Appeal Decision

Appeal Ref: APP/R4408/W/22/3298388

Vernon Road, Ward Gren, Worsborough S70 5BB

Site Name:	VERNON ROAD
3UK Cell ID:	BAR17366
Address:	VERNON ROAD WARD GREEN BARNSELEY SOUTH YORKSHIRE S70 5BB
Title:	265 PROPOSED SITE ELEVATION
Project:	UNILATERAL SW
Purpose of Issue:	PLANNING
Site ID:	BAR17366
Drawing No:	BAR17366_PLANNING_REV_A
Issue:	A

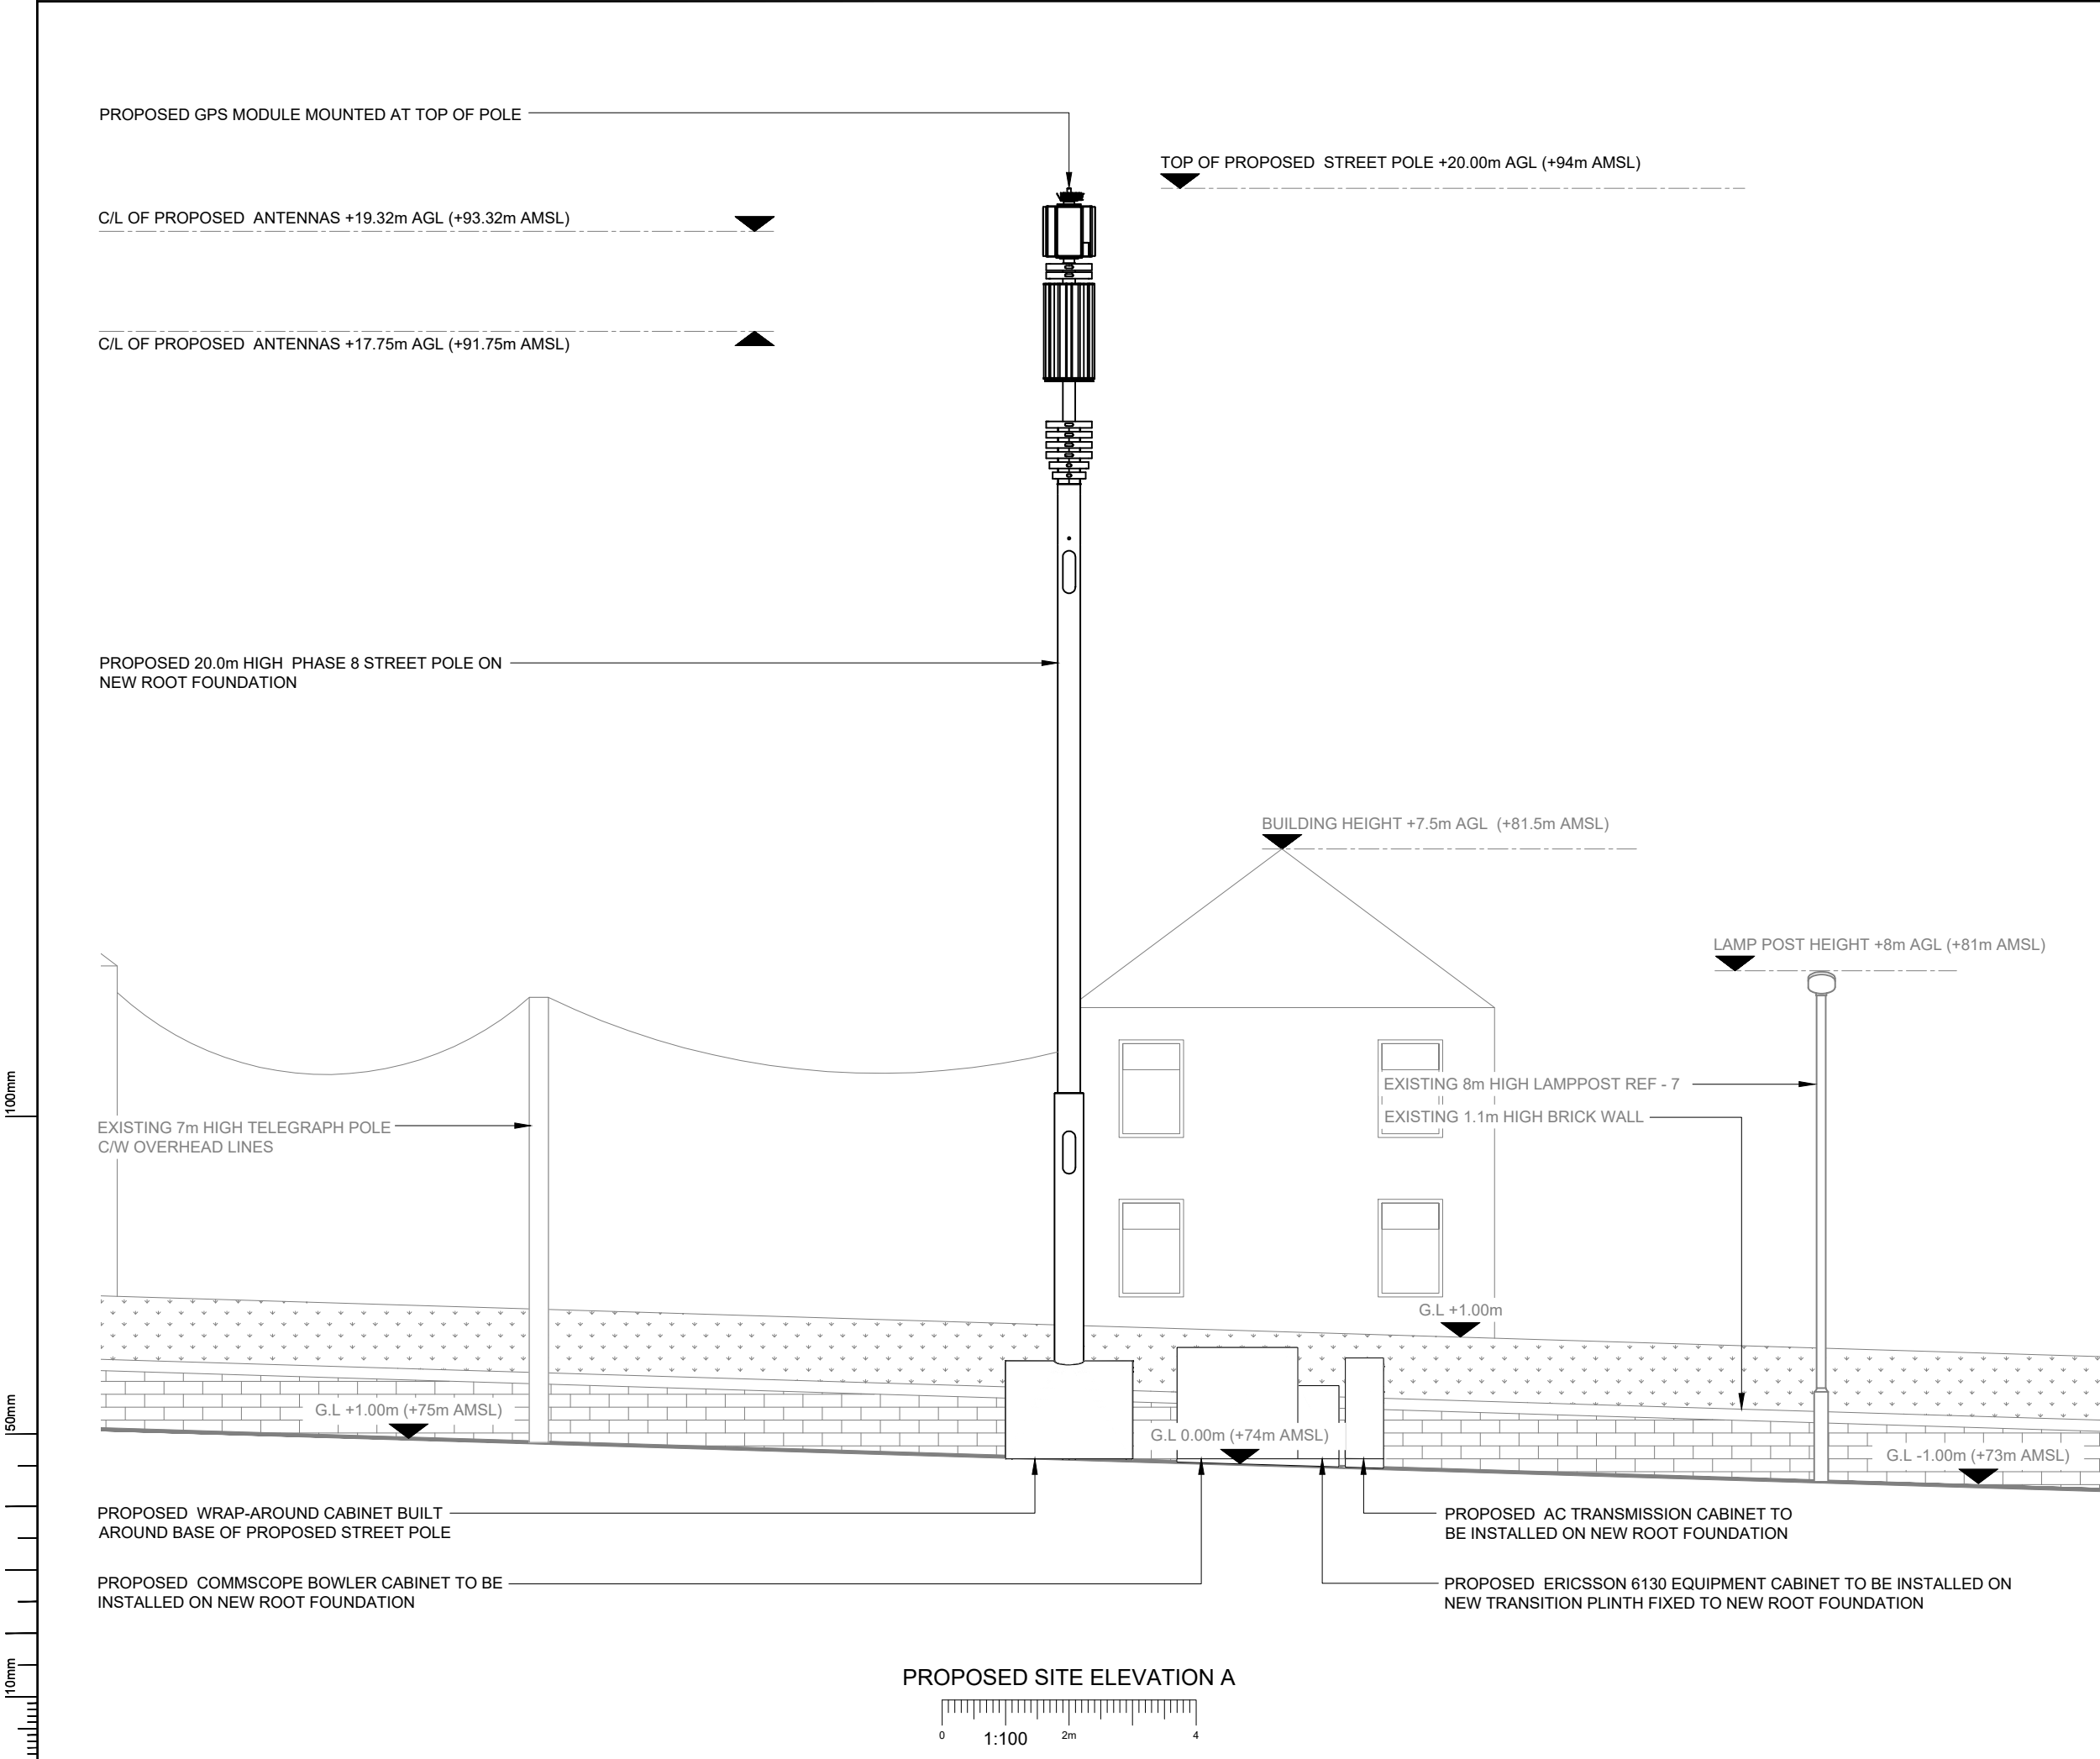
7. The appellants state that the proposed mast would facilitate Fifth Generation (5G) connectivity. The proposal would be visible above the existing streetscene profile of streetlights and residential property when seen in its context. The scale of the mast is strident, industrial in nature and has the external appearance of a structure more often seen in commercial or industrial areas and the mast would appear dominant in the locality and be harmful to the character and appearance of the area

8. The mast would be relatively slender in design, and a portion of the overall height is made up of antennas but would look significantly larger than any surrounding structures. I find that the mast and associated cabinets would introduce "street clutter" into the area and harm the character and appearance of the area by adding such an industrial style of development into the wider residential and grassed area.

9. I acknowledge the design attempts that have sought to minimise the impact of the pole, however the differences in height and thickness of the pole, in comparison with the surroundings, together with the additional clutter, would be very apparent. The proposed mast would be a discordant feature unlike anything around it which would be detrimental to the character and appearance of the area.
